Tuesday, March 14, 2017 11:35:24 AM

PLAN  NORTH **1** TYPICAL FINISH PLAN  
1/4" = 1'-0"

**1** GUESTROOM DOOR TYPES  
1/2" = 1'-0"

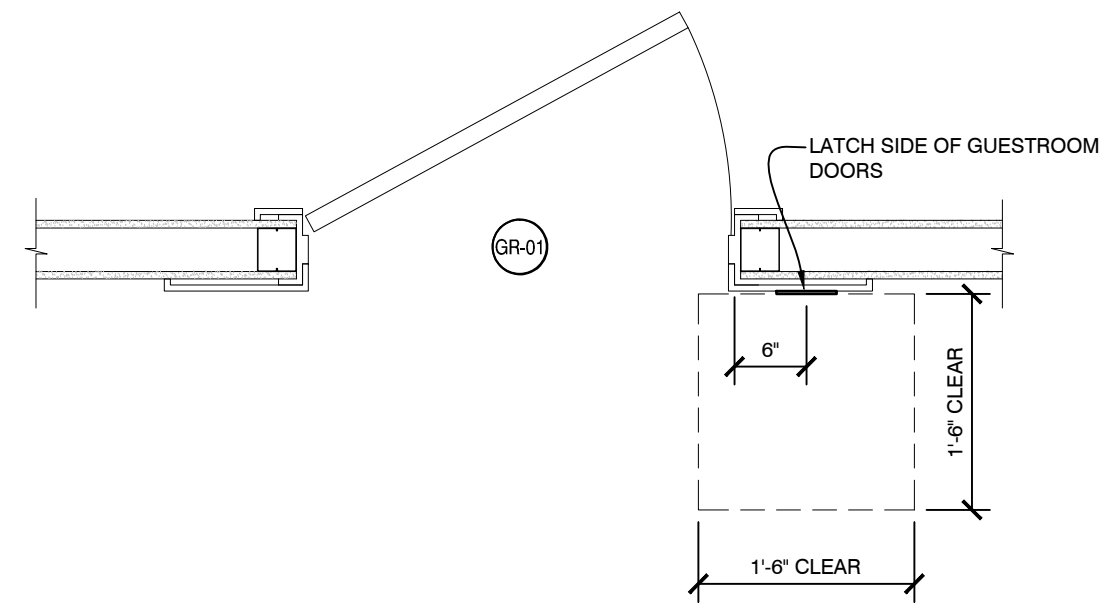
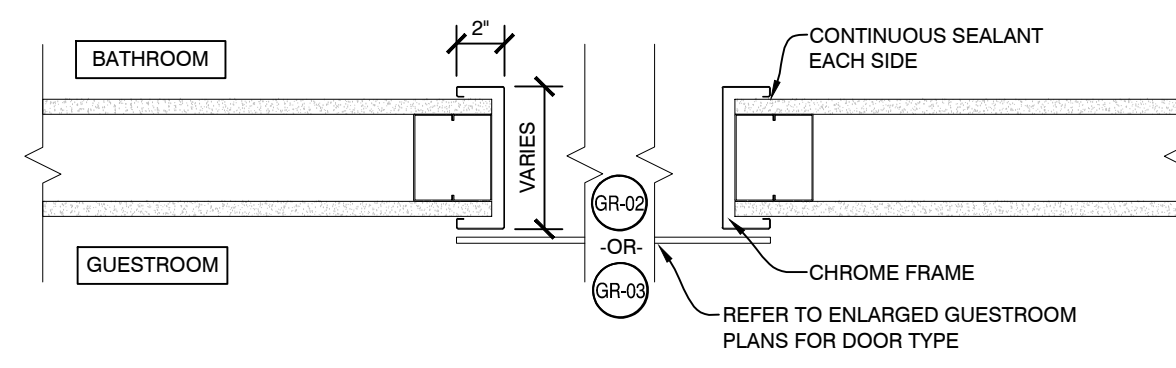
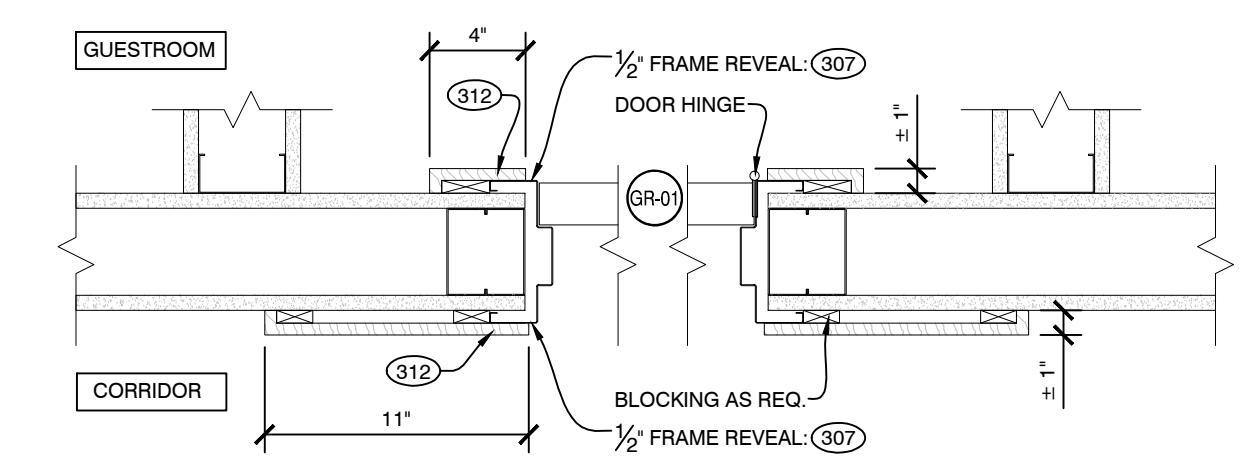
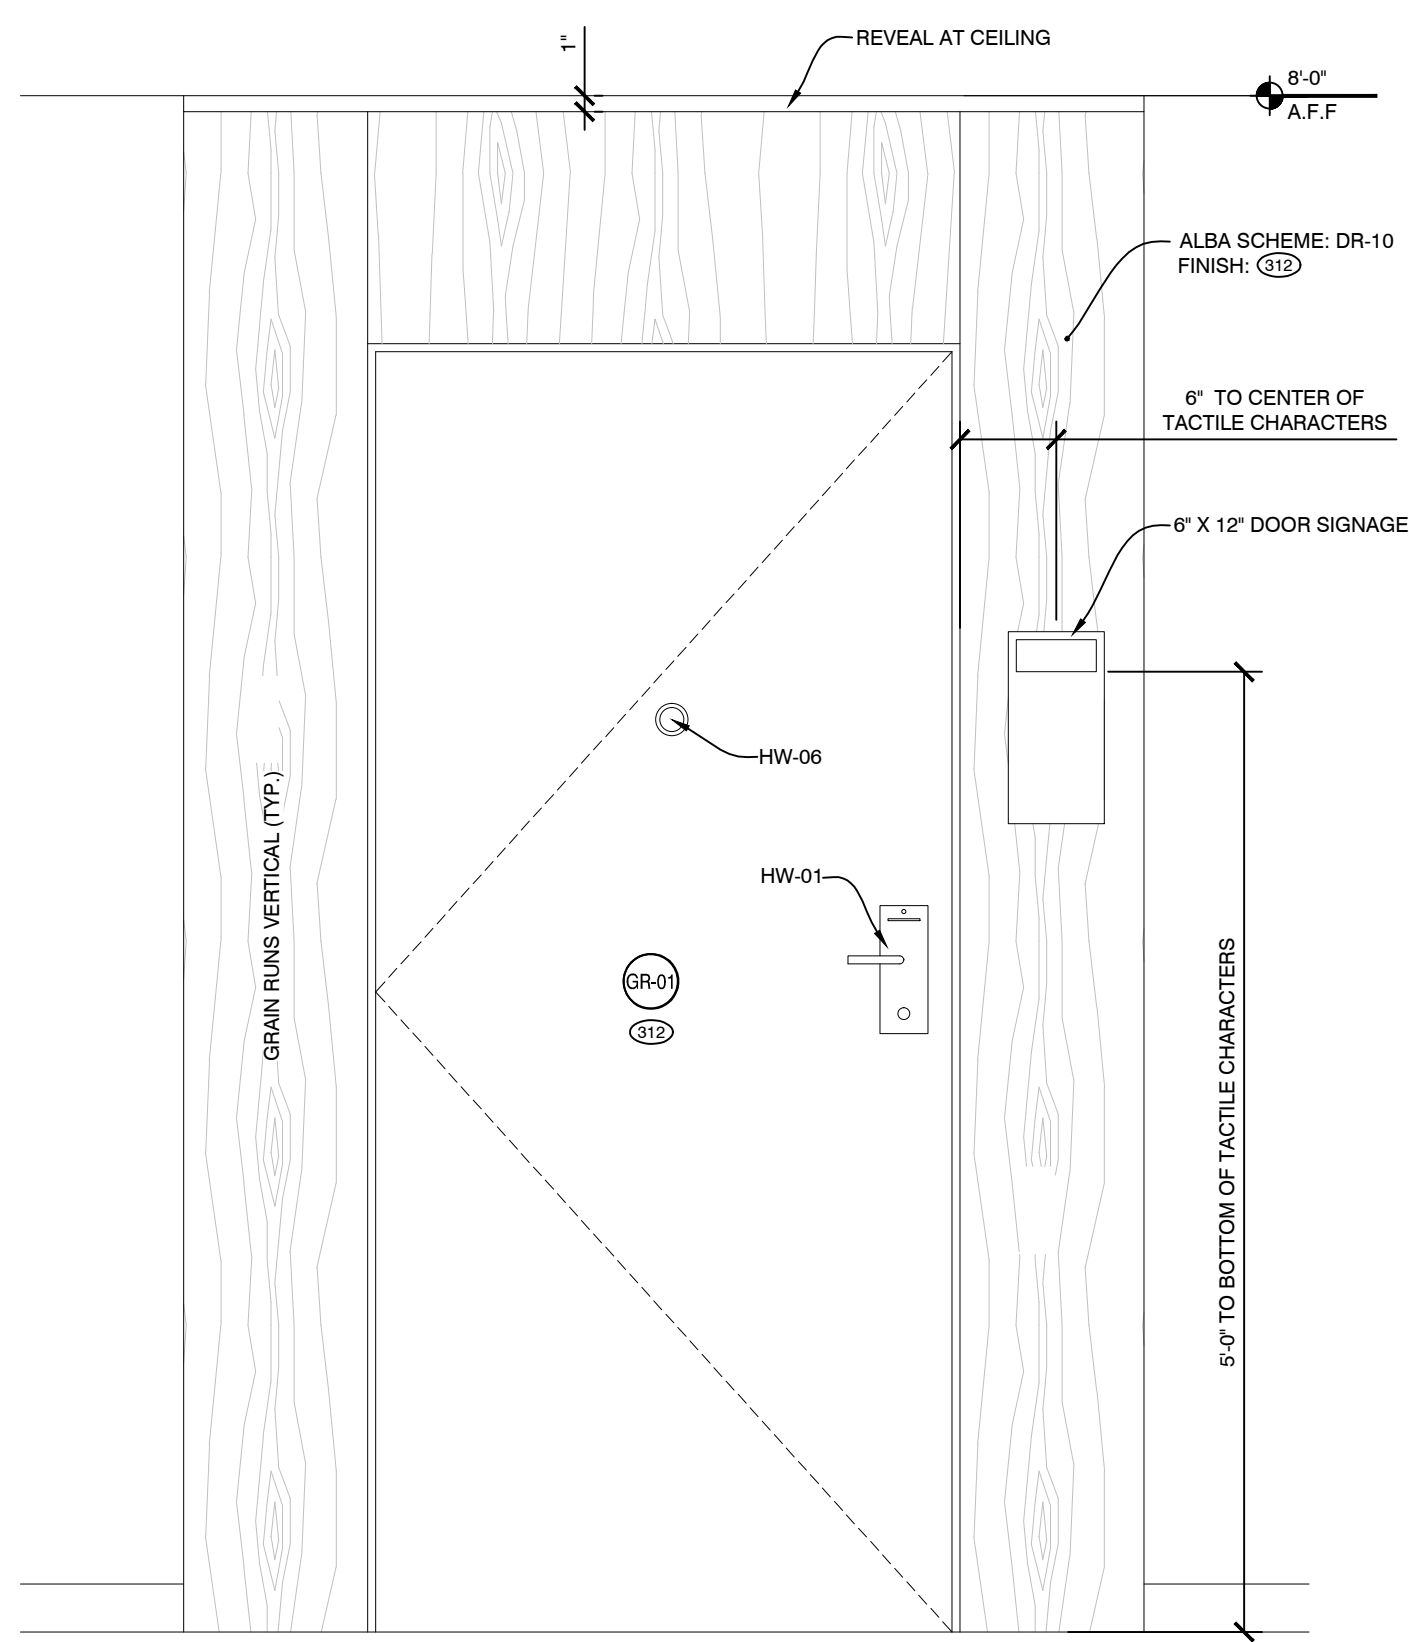
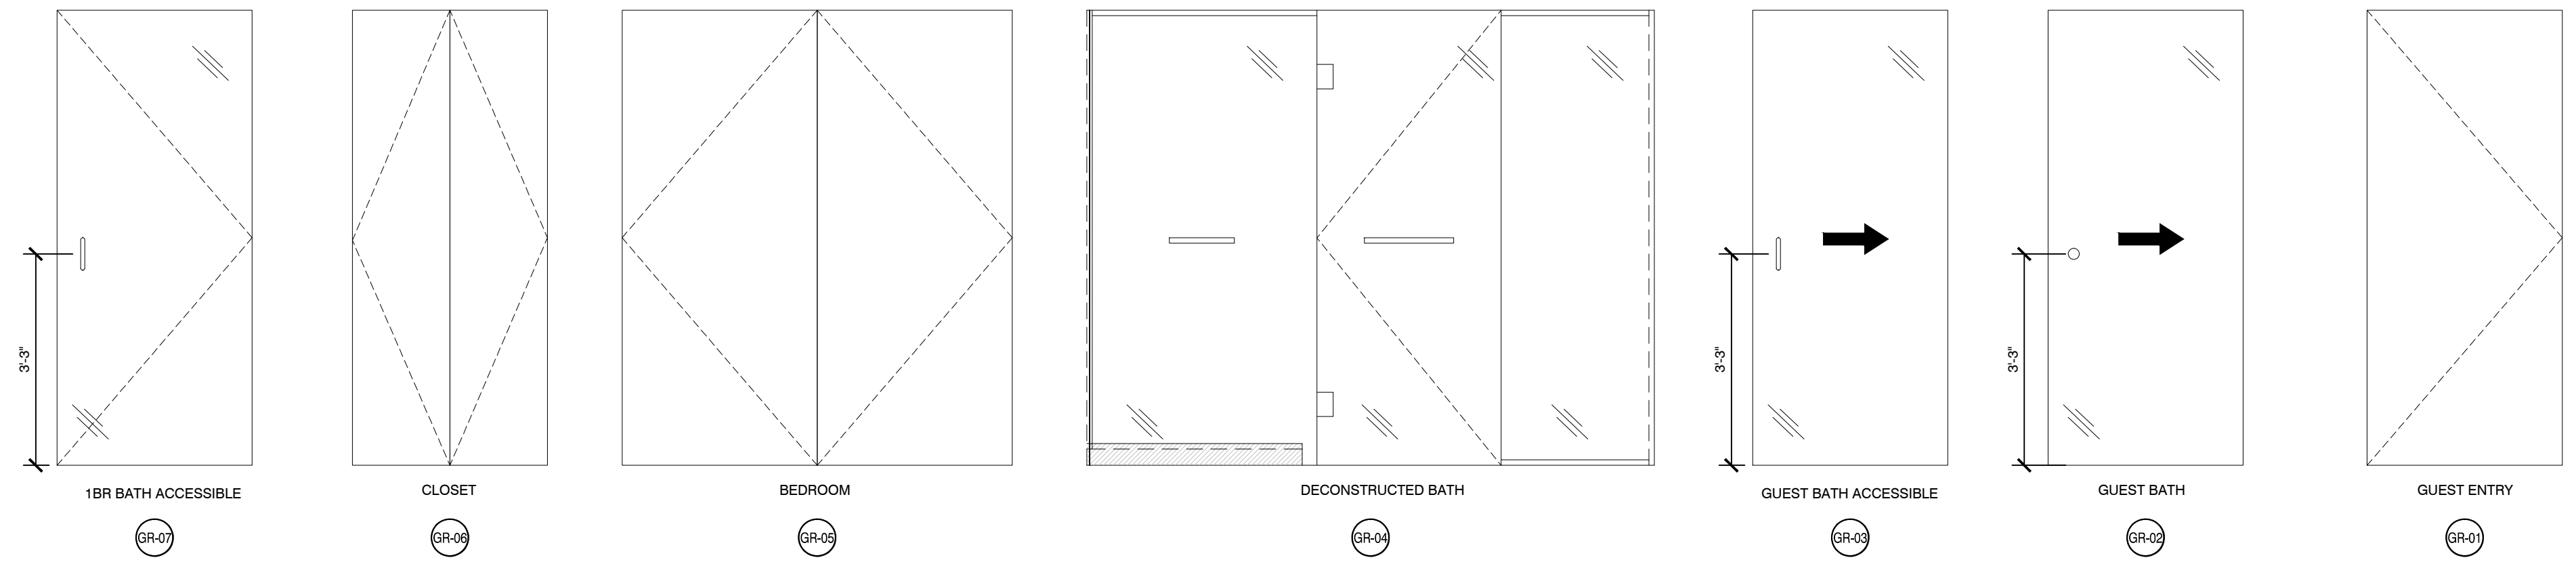
- ▽ HARD WATER PROOF FINISH SURFACE AT HYDRATION STATION. SUBMIT TO MARRIOTT FOR REVIEW.
- ▽ GLASS PANEL SURROUNDS AT ELEVATOR. SUBMIT TO MARRIOTT FOR REVIEW.
- ▽ PROVIDE TWO ROOMS ON EACH GUESTROOM FLOOR THAT CAN BE KEYPED TOGETHER.
- ▽ HPL DOOR SURROUNDS (AL-319)- SEE A5.04 FOR DETAILS. PANEL AT JAMB IS HELD BACK 1/2" FROM FRAME. PANEL AT HEADER IS HELD BACK 1" FROM CORRIDOR CEILING. DIMENSIONS TO BE VERIFIED IN FIELD PRIOR TO INSTALL.
- ▽ HPL WALL PANEL (AL-312) TO FILL IN BETWEEN INDICATED DOOR SURROUNDS. REFER TO A7.0X FOR ELEVATIONS & DETAILS.
- ▽ BASE BOARDS CAN BE PURCHASED THROUGH MARRIOTT AND IS IN THE ID SPEC MANUAL.
- ▽ ANY GAP LEFT BETWEEN THE FLOORING MATERIAL AND THE GUESTROOM WALLS SHOULD BE NO MORE THAN A 1/2" SO THAT THE BASE WILL COMPLETELY COVER THIS GAP.
